Construction of 1No. 2 bedroom chalet bungalow
Land adj to 65B Gravits Lane Bognor Regis

Thank you for your internet representation made on 12th September 2014 which has been recorded as '**an objection**' with the comments as follows:

BLOCK / LOCATION PLAN
LAND ADJACENT TO 65B GRAVITS LANE BOGNOR

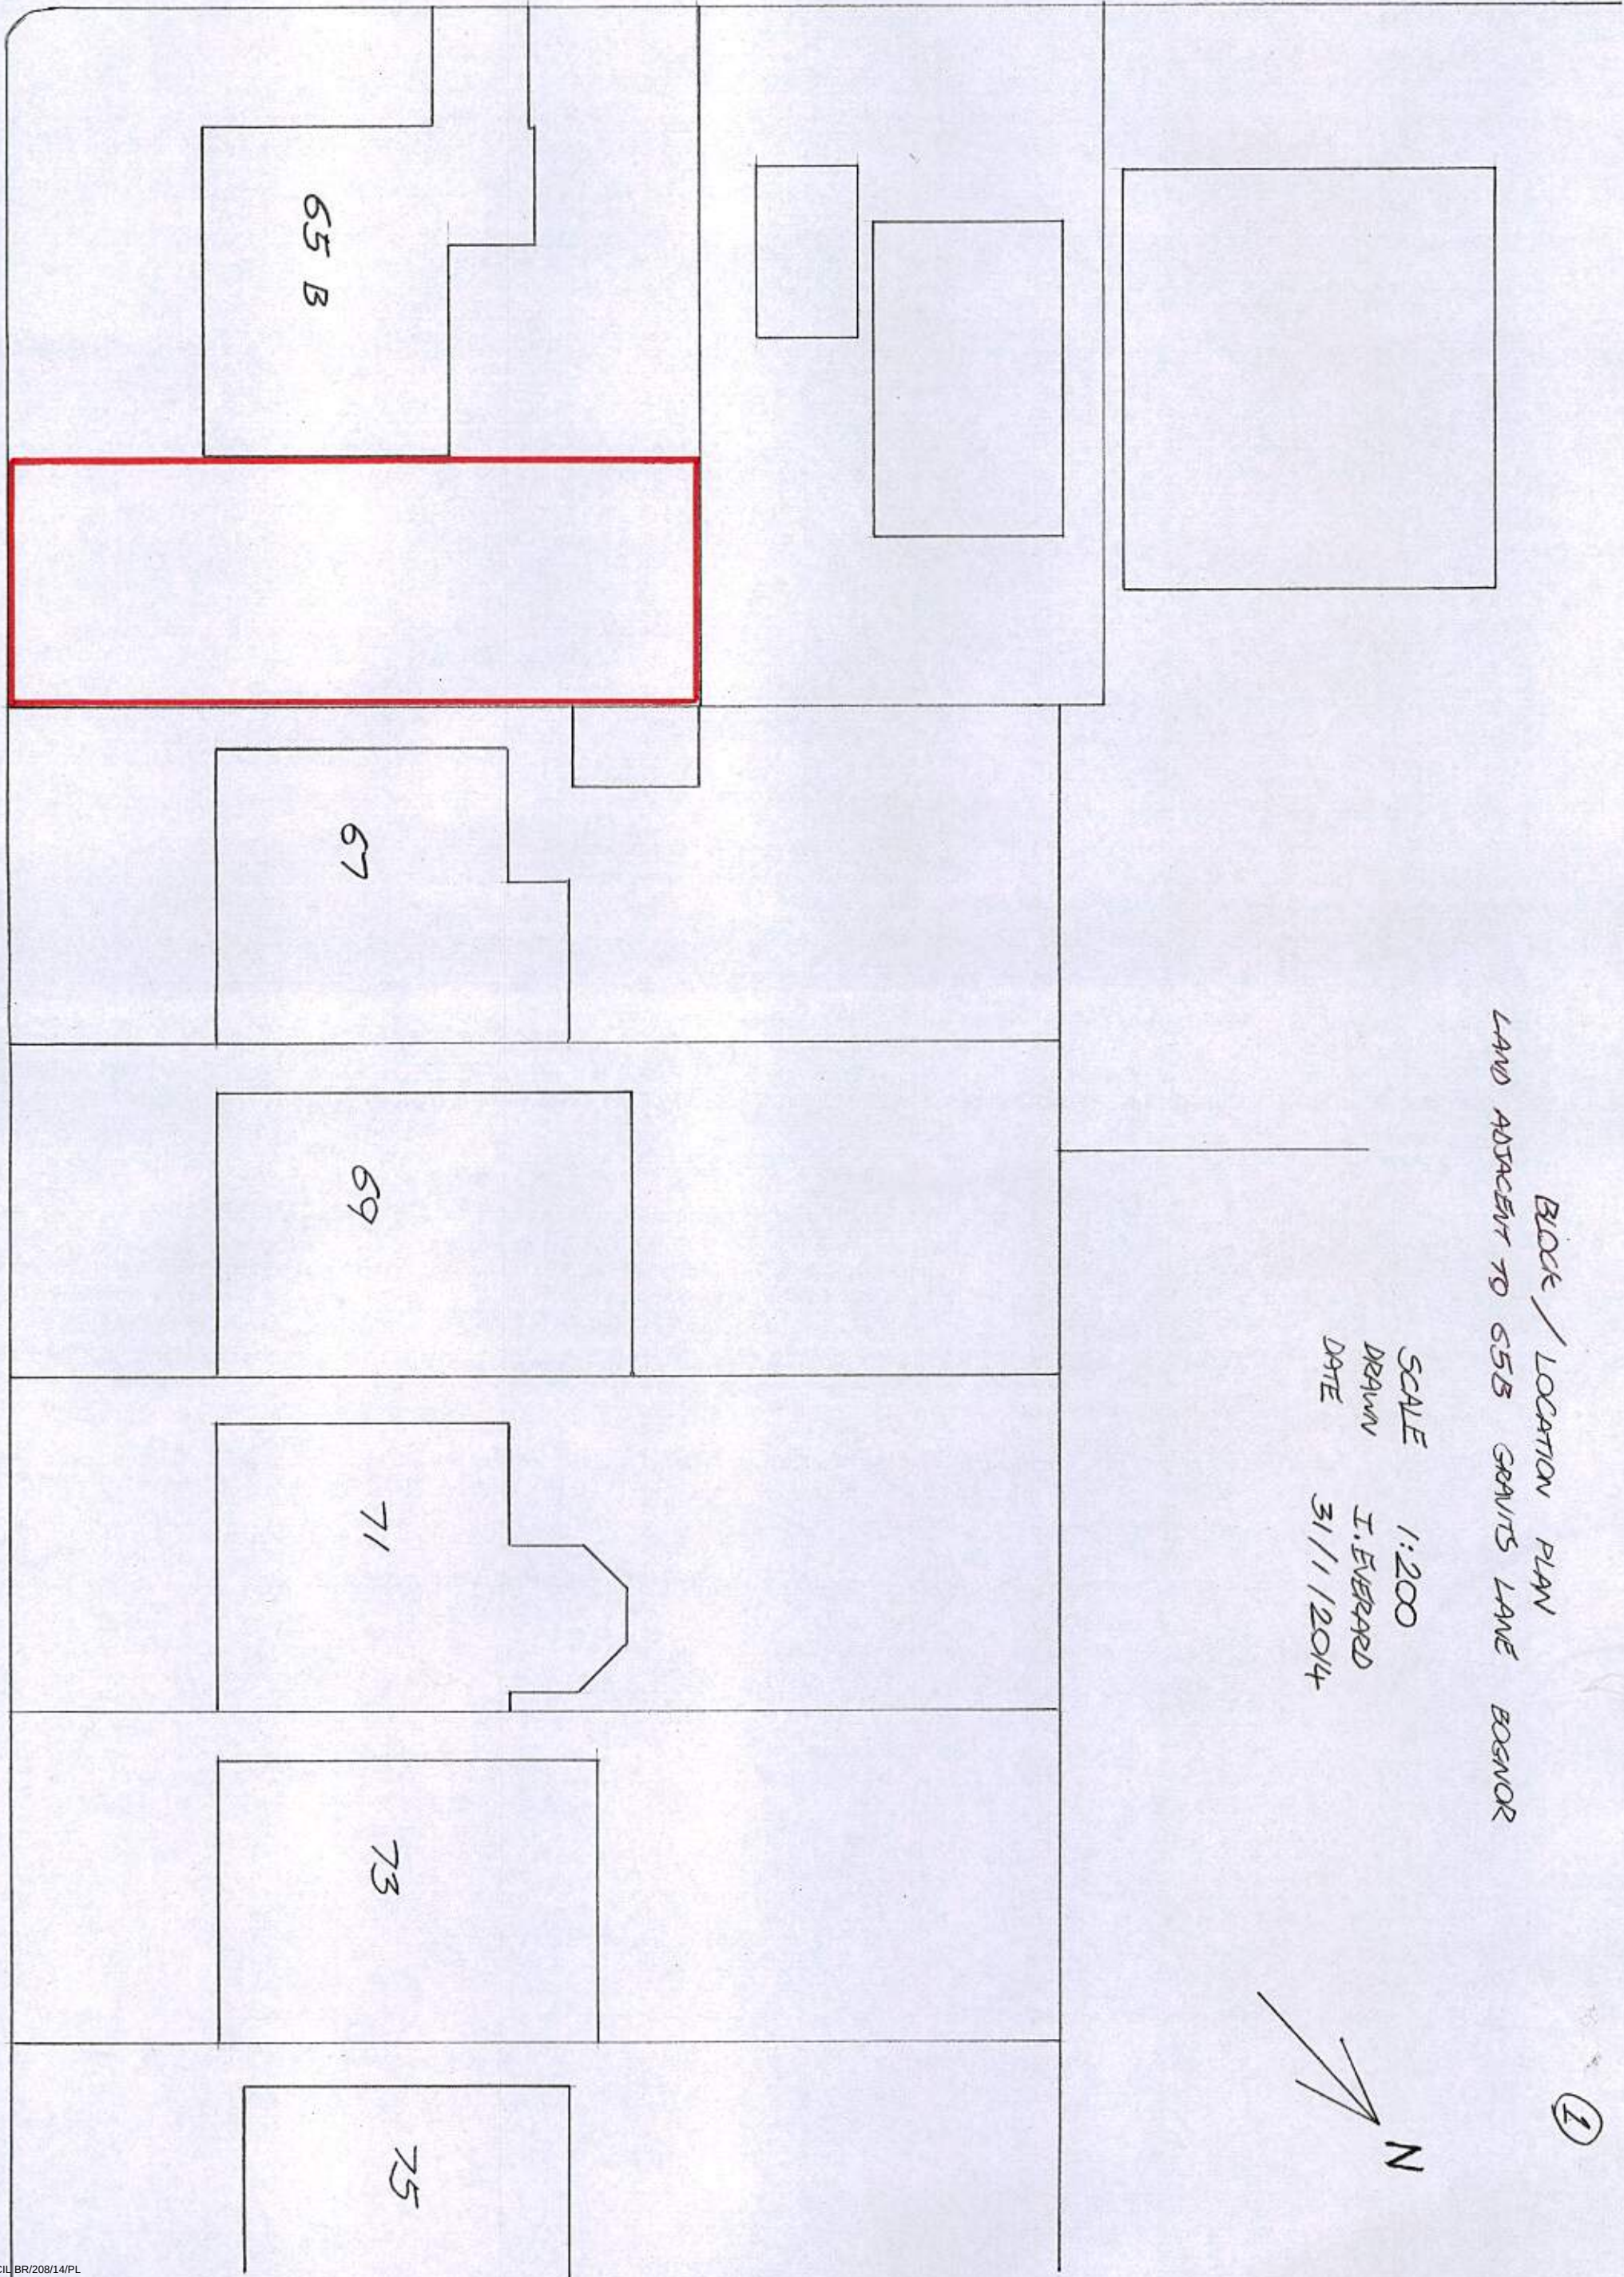
- 1. Land too small, house will look undersized to other bungalows.*
- 2. Too overcrowding for extra vehicles for on street parking.*
- 3. Will make junction more of blind/hazardous junction.*
- 4. Proposed build will be built in front of water pump station, any extra vehicles parked outside this property, will limit access for tankers.*
